**From:** Bloomer, David <David.Bloomer@lancashire.gov.uk>  
**Sent:** 29 June 2015 10:54  
**To:** Colin Sharpe  
**Cc:** LHS Customer Service; planning  
**Subject:** app3/2015/0411 Prestons Yard Longridge

Notwithstanding the issues arising from the proposal to introduce direct access parking to residential properties opposite a school entrance which has inherent highway safety implications, the proposal is for 4 x 4 bed which would suggest a parking provision of 3 vehicles for each of the properties. Of the 4 properties , 3 have 2 parking spaces and the 4<sup>th</sup> ( the Ascot unit) has 3 including the garage. In a village location with limited on street parking this under provision would not be acceptable/. Looking at the parking spaces provided for the individual units

FRONT
'YORK' FLOOR PLANS 1:100

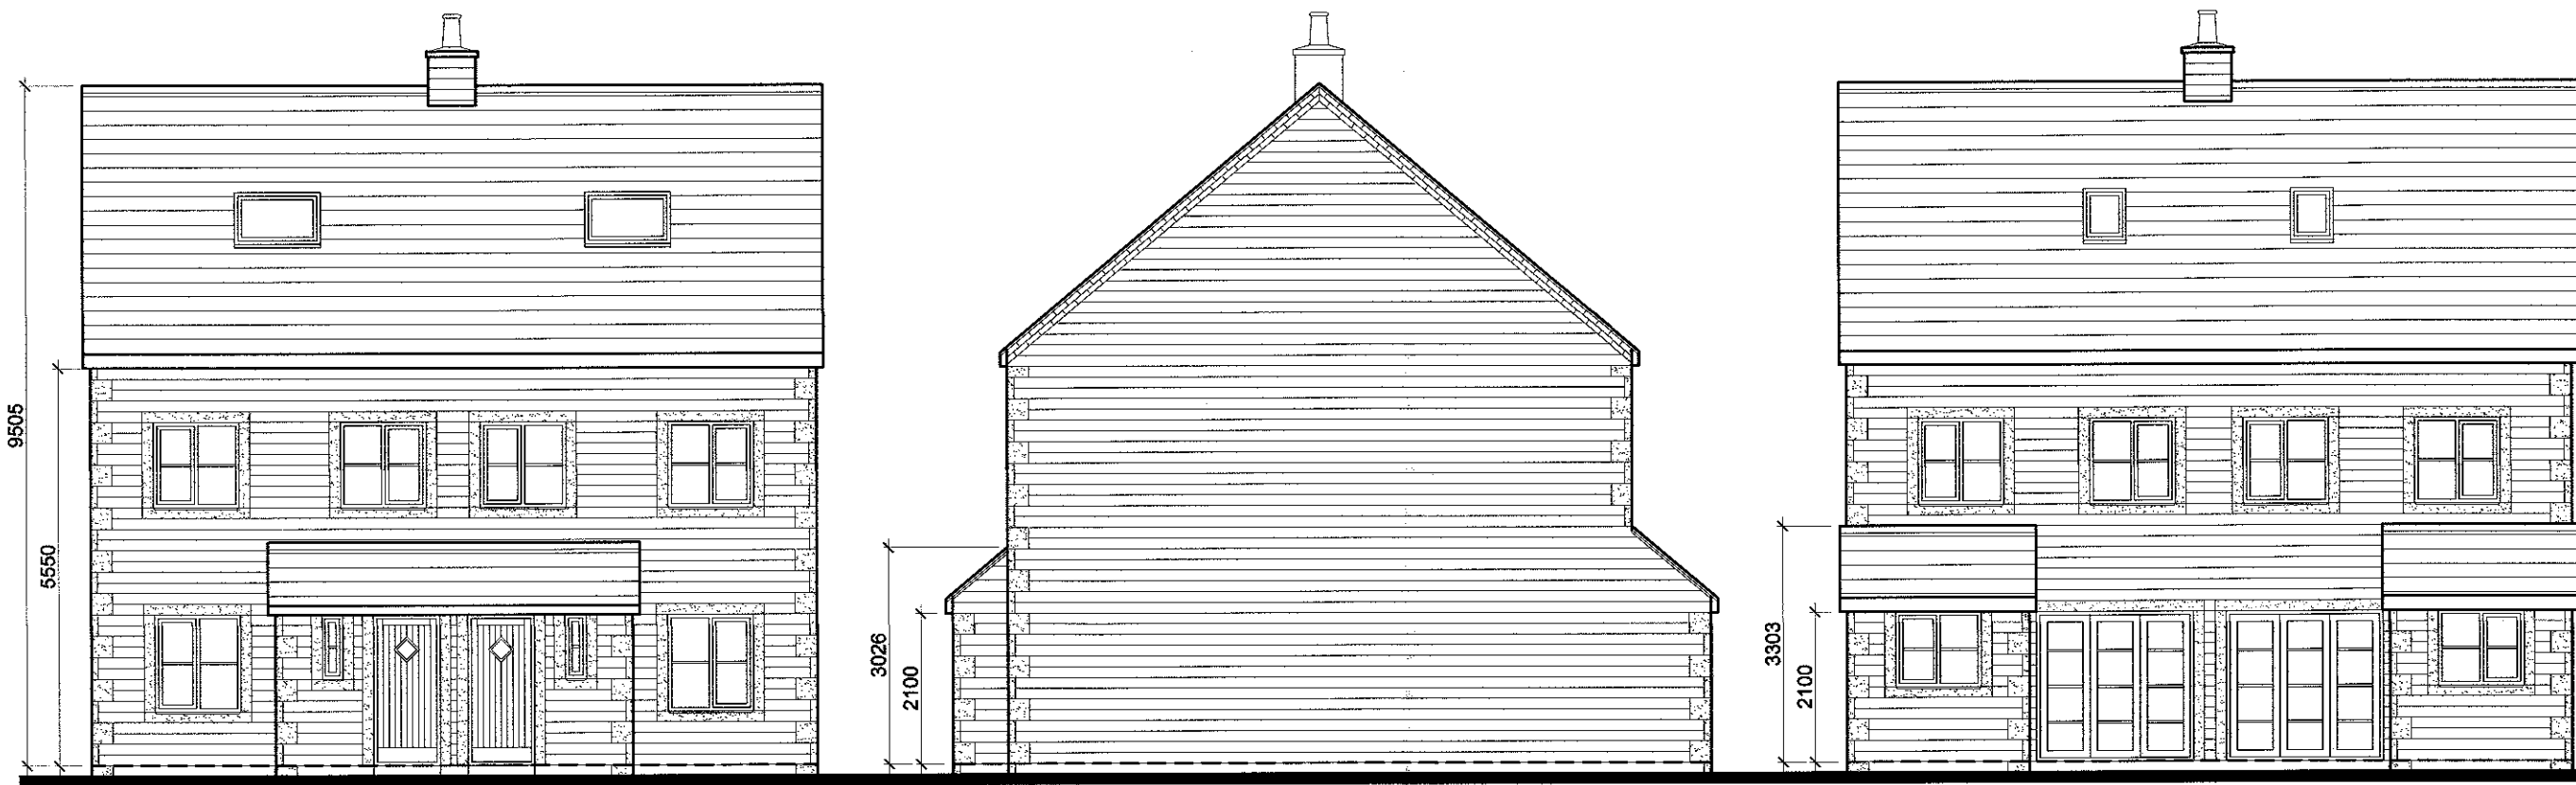
York, The length of the spaces is too short, with pedestrian access required to the properties there would be the likelihood of encroachment into the footway. There is insufficient width for vehicles to be parked side by side and still retain sufficient access for pedestrians.

'ASCOT' FLOOR PLANS 1:100

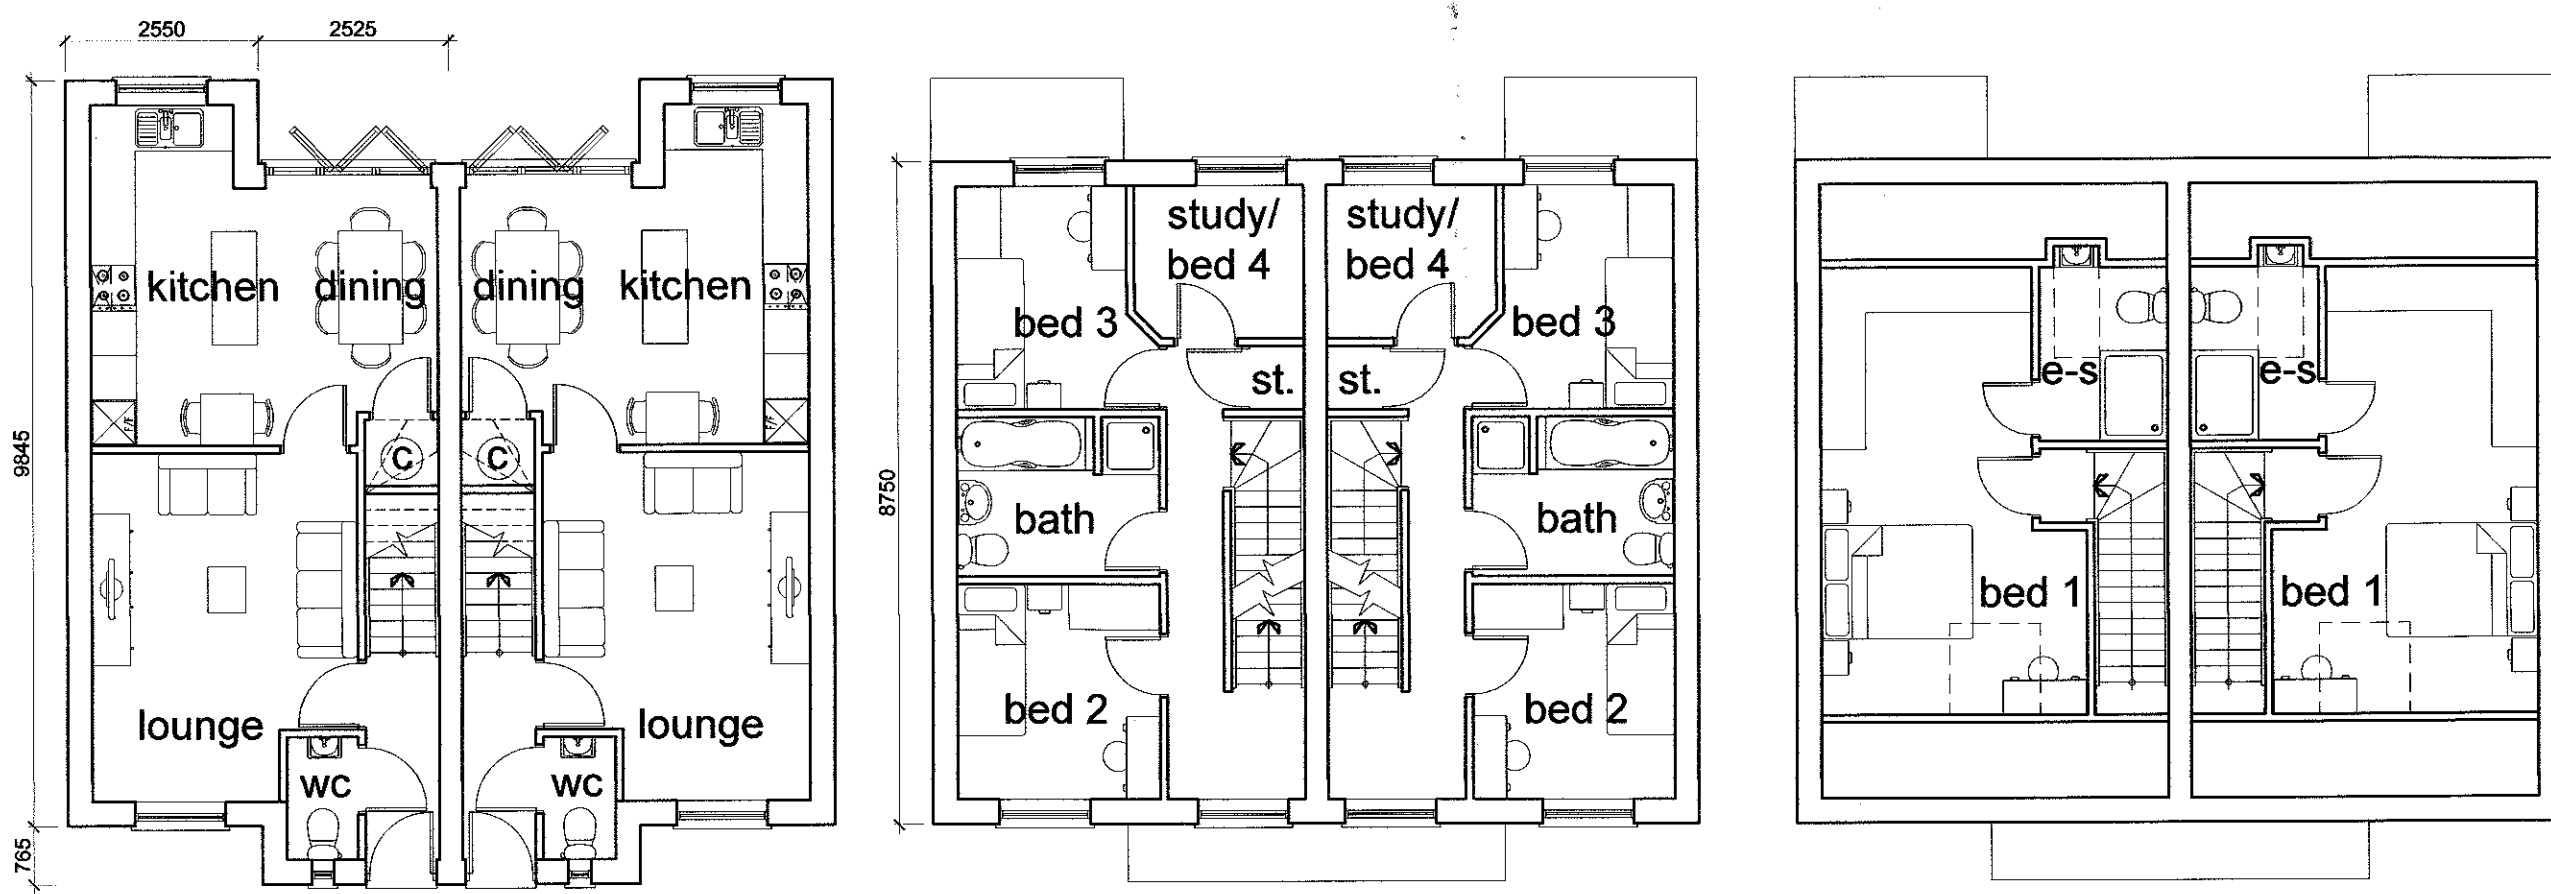
Ascot the drive length is 4.6 metres which would lead to encroachment into the footway. The parking spaces are shown tight up to the building frontage and doesn't allow for access to either the front door nor the garage ( even assuming a roller shutter garage door)

'NEWBURY' FLOOR PLANS 1:100

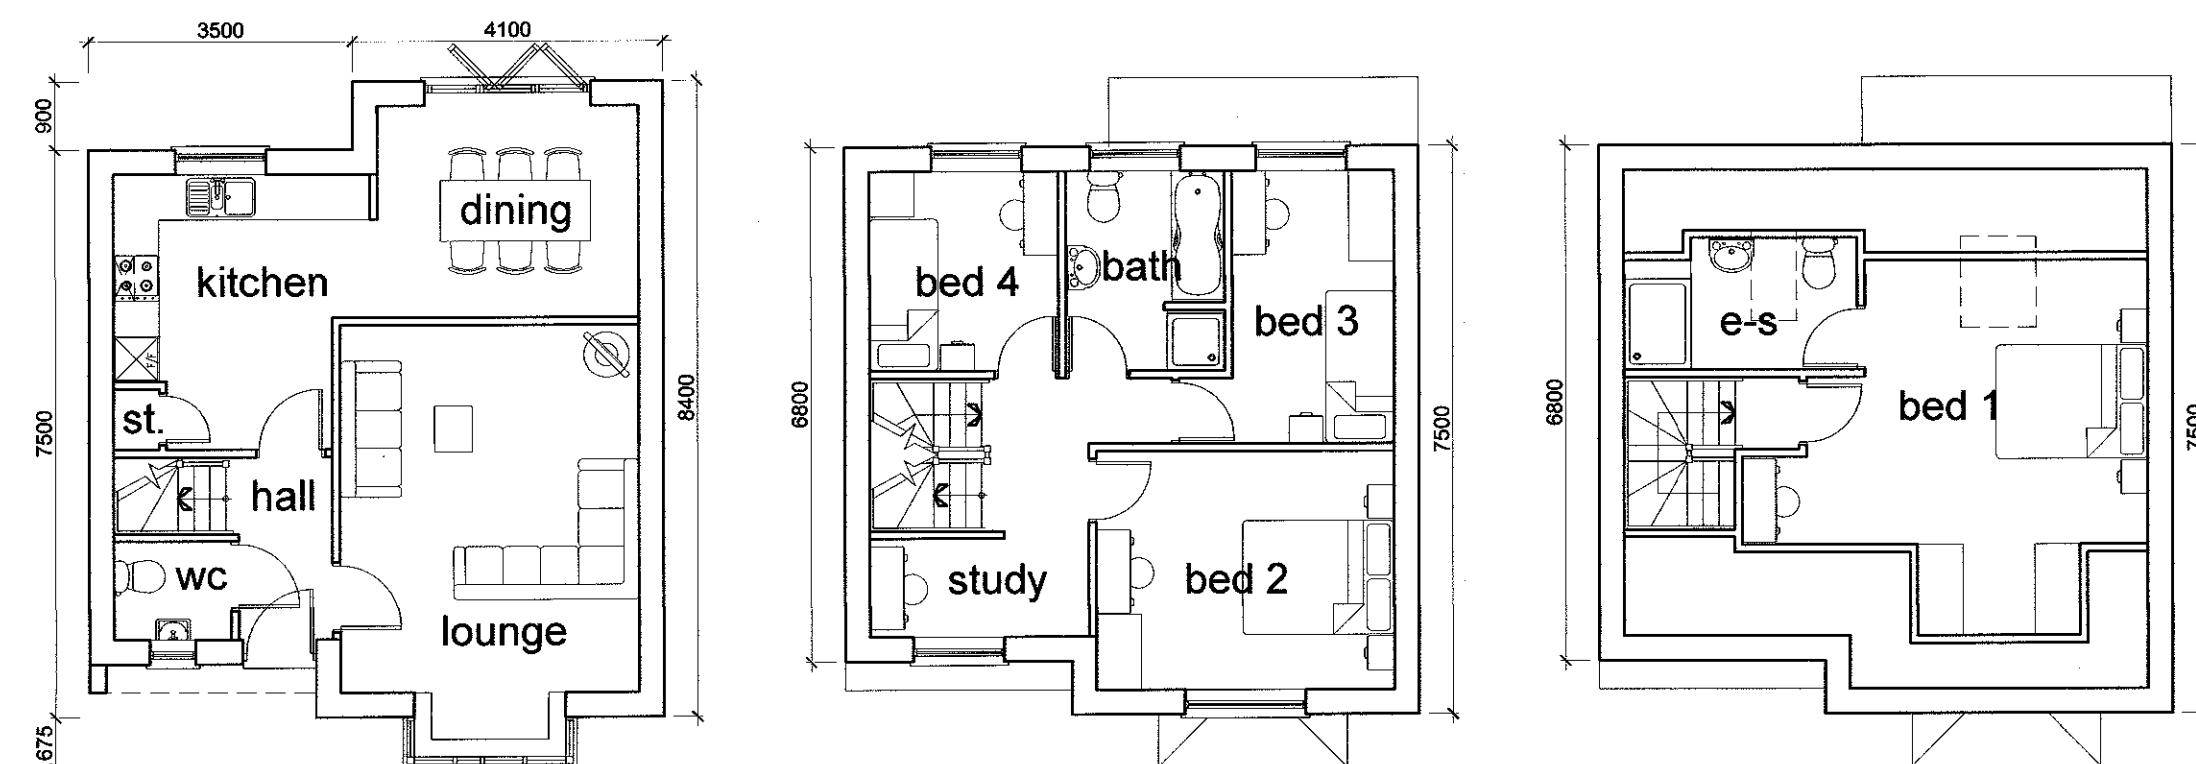
Newbury. The drive at the side of the house narrows to a wall to wall dimension of 2 metres which would restrict the use of this space, also the spaces are 4.8 metres in length which coupled with the width issue would lead to a likelihood of vehicles encroaching over the footway
